Reference: FG/74/22/HH

Sumara, The Warren, Ferring BN12 5PQ

Proposal

Front and rear dormer replacement. Replacement green roof and reinstatement of chimney and associated works. Removal of two rear conservatories and replace with terrace. Alterations to fenestration and render system to brick facades.

Proposed North and East
Elevation

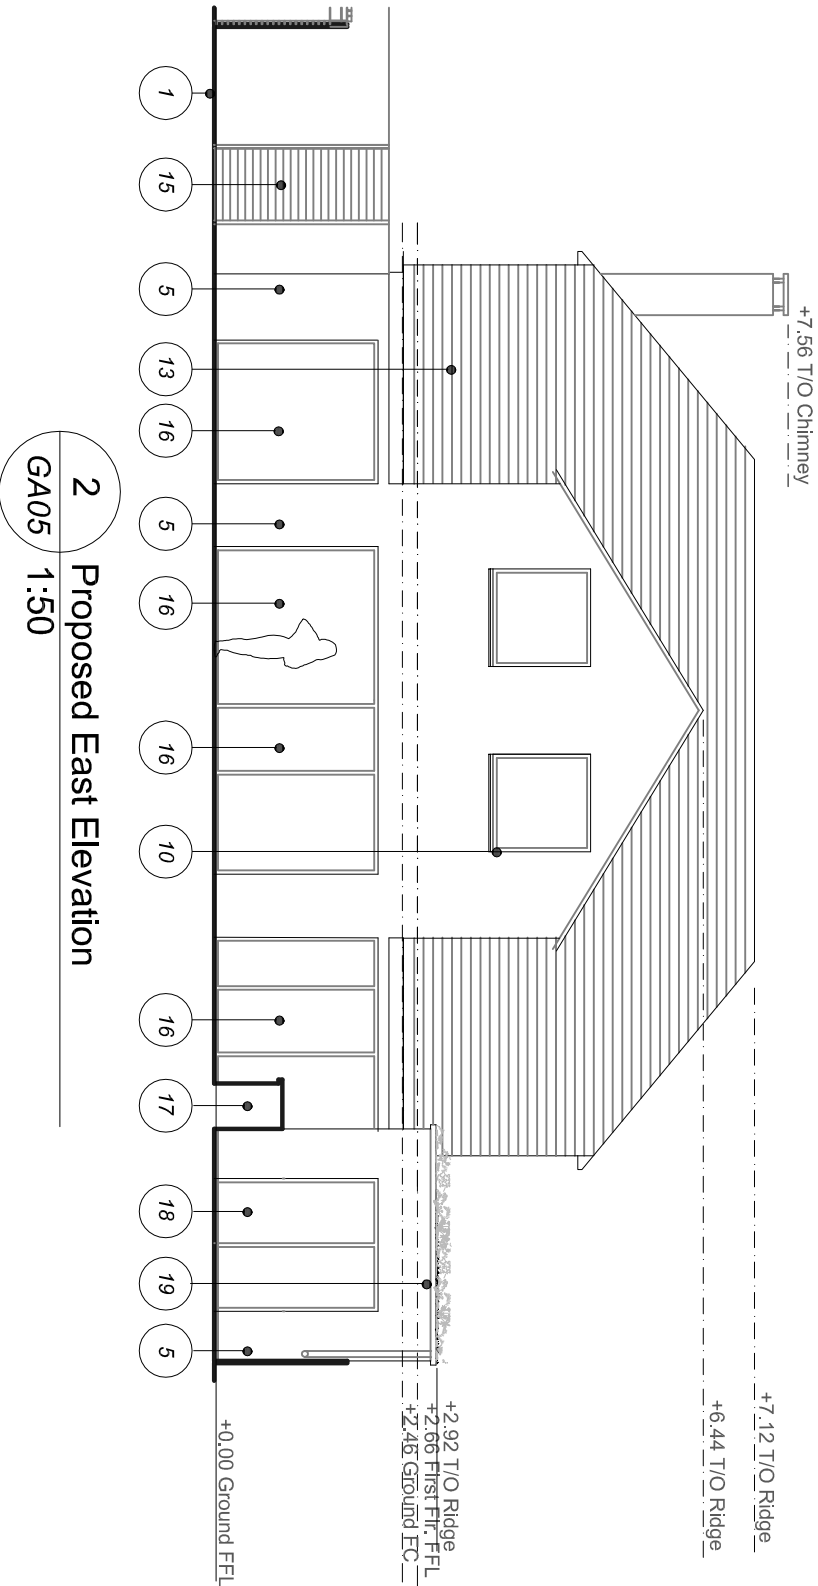
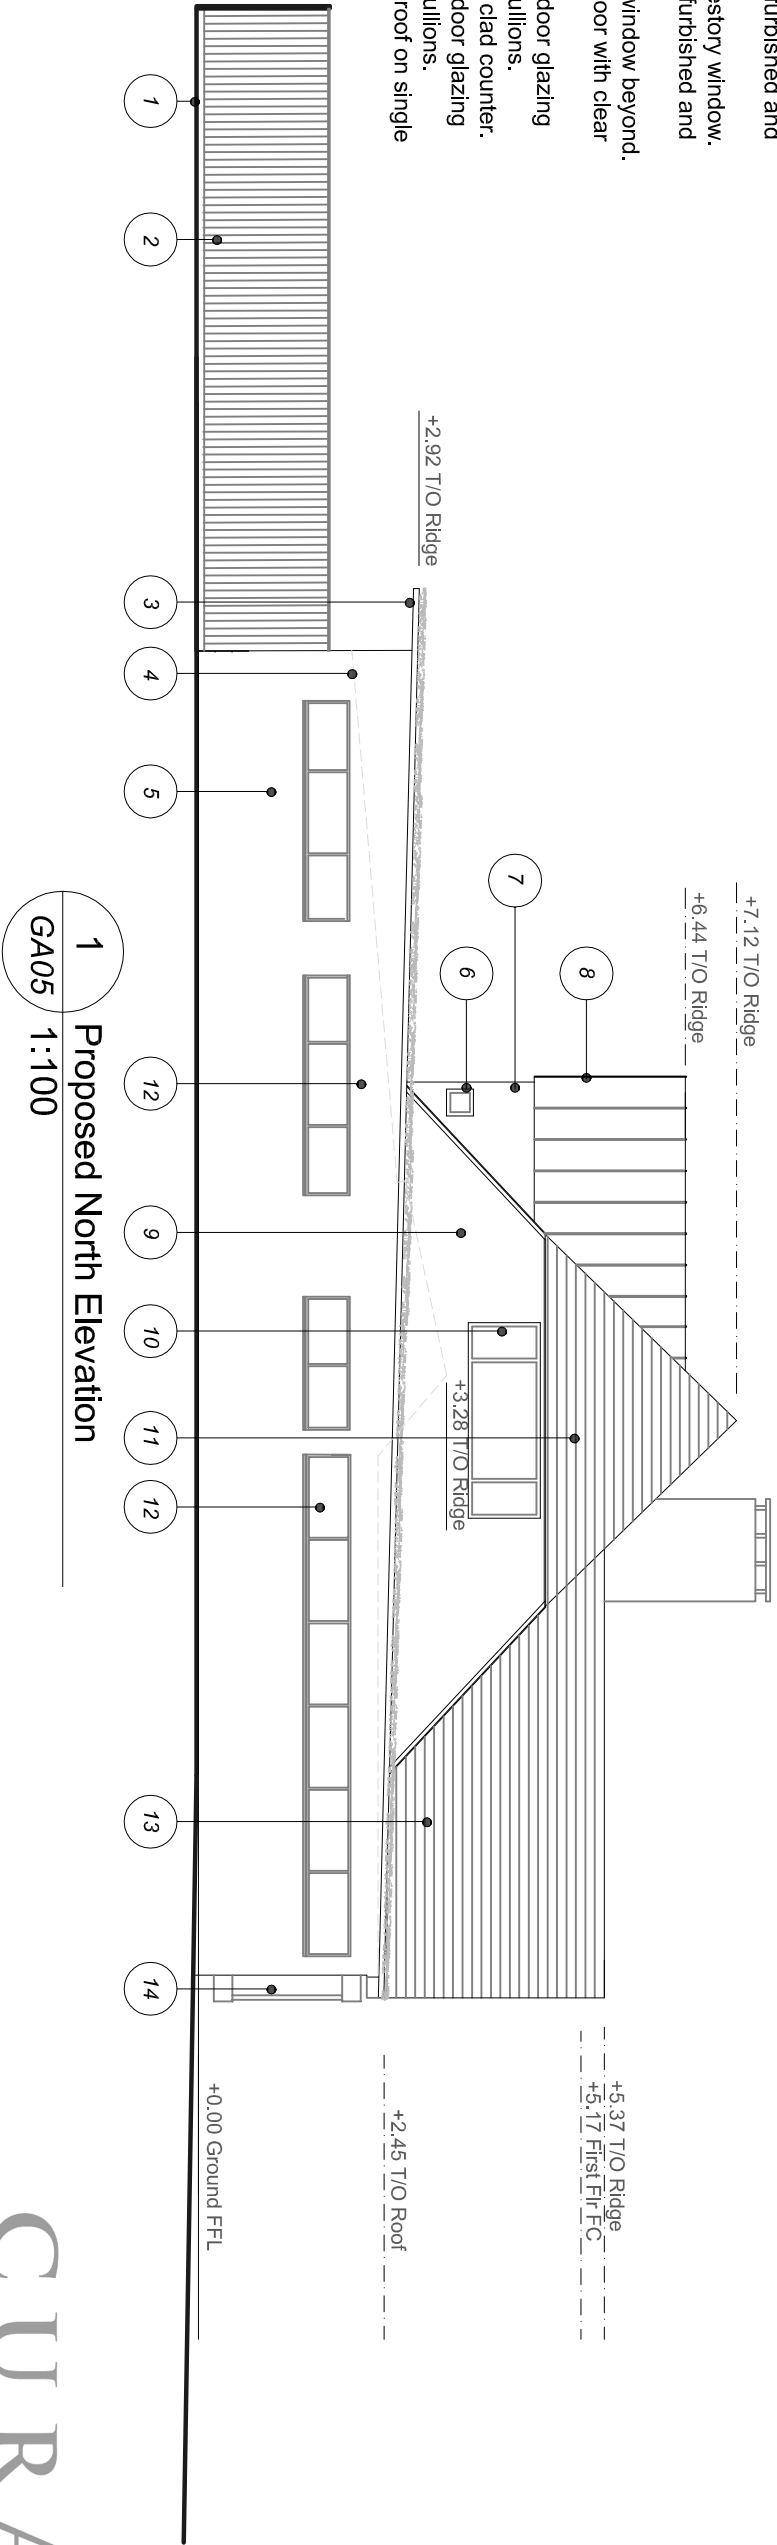
The proposed new fence on Sumaras North boundary; we believe to be our fence and responsibility, according to the deeds that we possess for Briar Croft and the previous owner of Sumara also believed this was our boundary fence. It is only two years old, strong and in perfectly good condition, attractive with climbers and bird boxes adorning it, it's visually in keeping with other fences that we and our neighbours to the North and East have, there is no need to change it and if doing so will be a disruption and a disturbance to us.

The 'Replacement green roof' which is far more than described in the Architects Design and Access Statement (31f8cacf9e19453.pdf), the understated term 'replaced' is used often throughout the document, but it's much more than that, it's a total redesign. The proposed design increases the height of the building at one end by almost a metre. The property although detached, the North side of the development is our Southern boundary and this change will directly impact the natural light that comes in from the South being 2.92 metres in height and will be even higher depending on plant selections for the green roof.

The planning application also specifies that this North side of Sumara will be rendered as per the new owner's tastes, yet this is our visual side of the boundary, the property isn't isolated or remote, it is not set back at all – it's right next door. Currently having a brick facade with plant borders, a raised bed with soil three bricks below the damp course growing shrubs, roses, other perennials and climbing plants with Robins and Tits nesting here during the nesting/fledgling season. They have returned to this site for several years – their habitat along with the foliage will be destroyed. This seems to be in contradiction to the Design and Access Statement (point 7.0 Evaluation): "the green roof element will benefit the biodiversity of the area providing a habitat for local butterflies, birds and insects" yet the wildlife that's already present on our property is ignored.

GA01

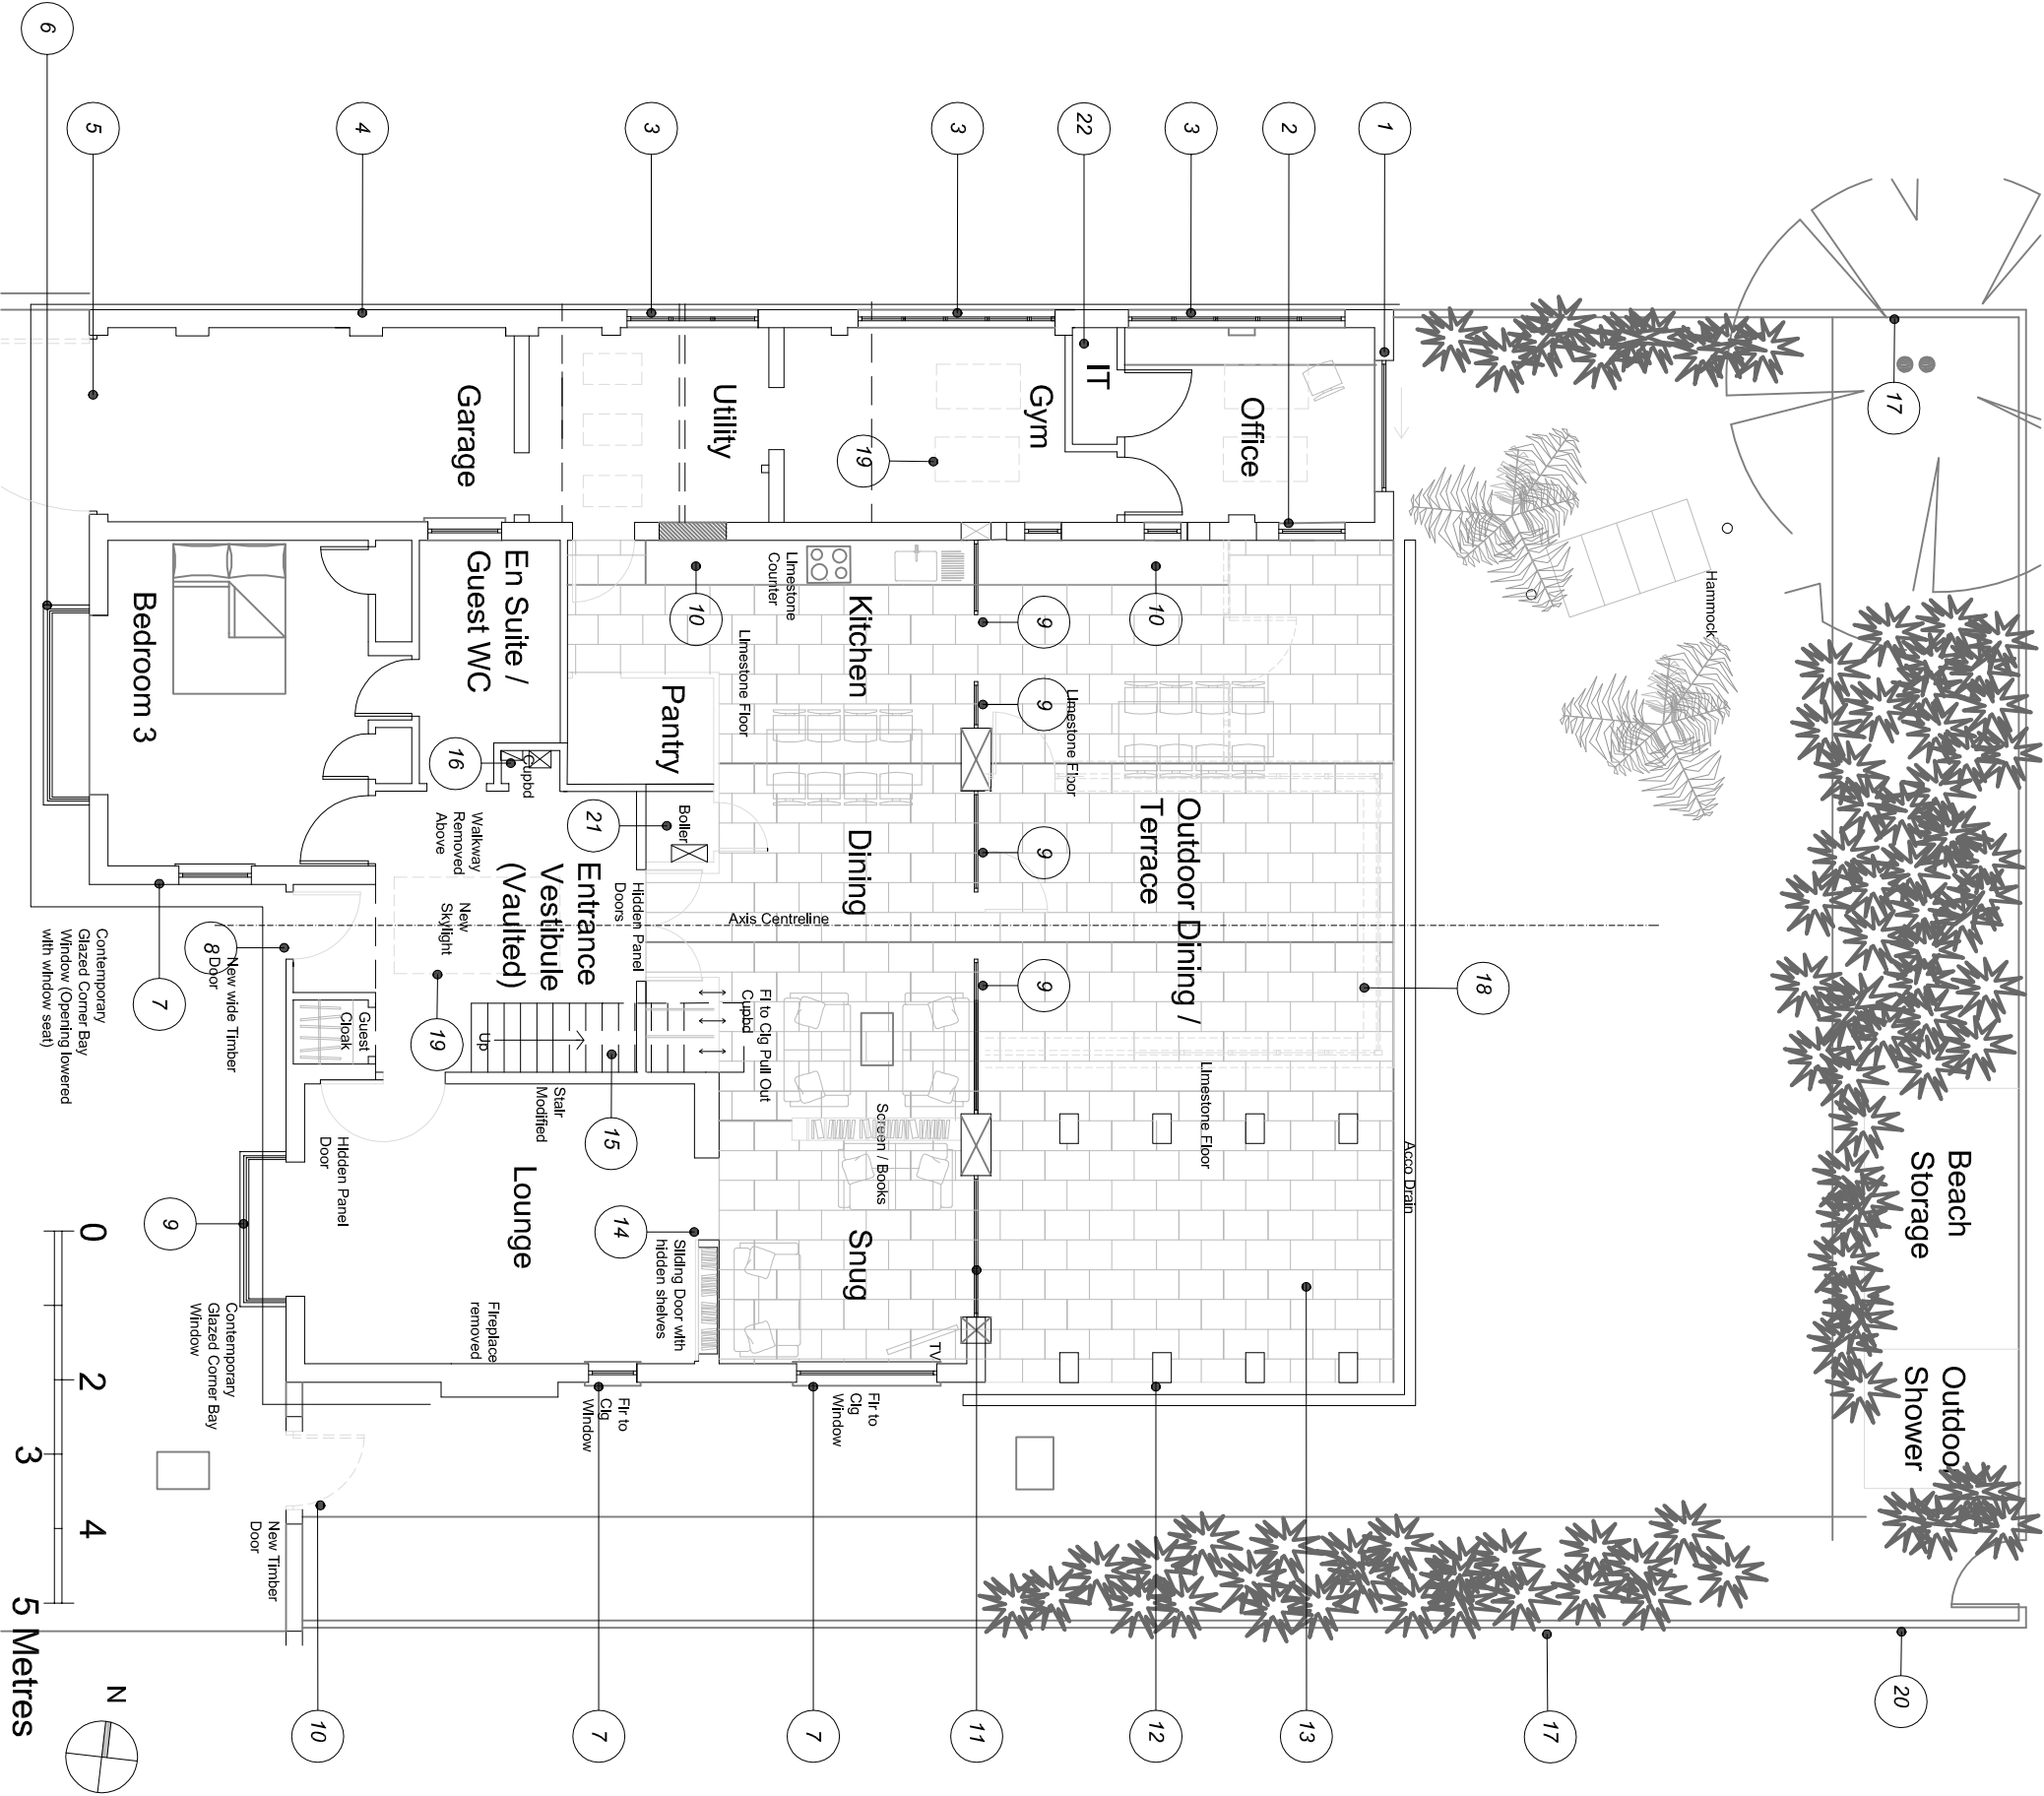
We object to; the installation of 14 'clerestory windows' on the North boundary wall of the current garage/outbuilding, the proposed office/gym/utility, that will directly face and overlook our property's main living spaces of our lounge, kitchen diner and garden at a distance of... zero. We anticipated the replacement of the 6 windows on the garage, but not the lowering of their position and the addition of 8 more windows at the same lowered height. Labelled as 'clerestory windows' on the drawing plan GA05 (Number 12) with the Sill at approximately 1.5 metres from the ground and therefore at our direct eyeline, they are not 'clerestory windows' they are just windows. Although opaque, they will always give the impression that we are being viewed from the other side, which is untrue, but a window is a window nonetheless. They will have an adverse effect on us with a loss of privacy and create light pollution in the evenings and at night.

These proposed windows are North facing and will not be immensely illuminating. If one studies the GA01 drawing the office has an East facing large set of sliding patio doors (Number 1) and South facing floor to ceiling window (Number 2) and a South facing window that's not labelled on the GA01 but can be seen. Added to this the proposed green roof above the office has 2 skylights with 5 more across the structure. Many would agree that that's a very bright office even without the addition of three opaque windows. The gym has 2 skylights and another South facing window that's not labelled on the GA01 drawing but can be seen and on the GA08 drawing plus the utility room has 3 skylights.
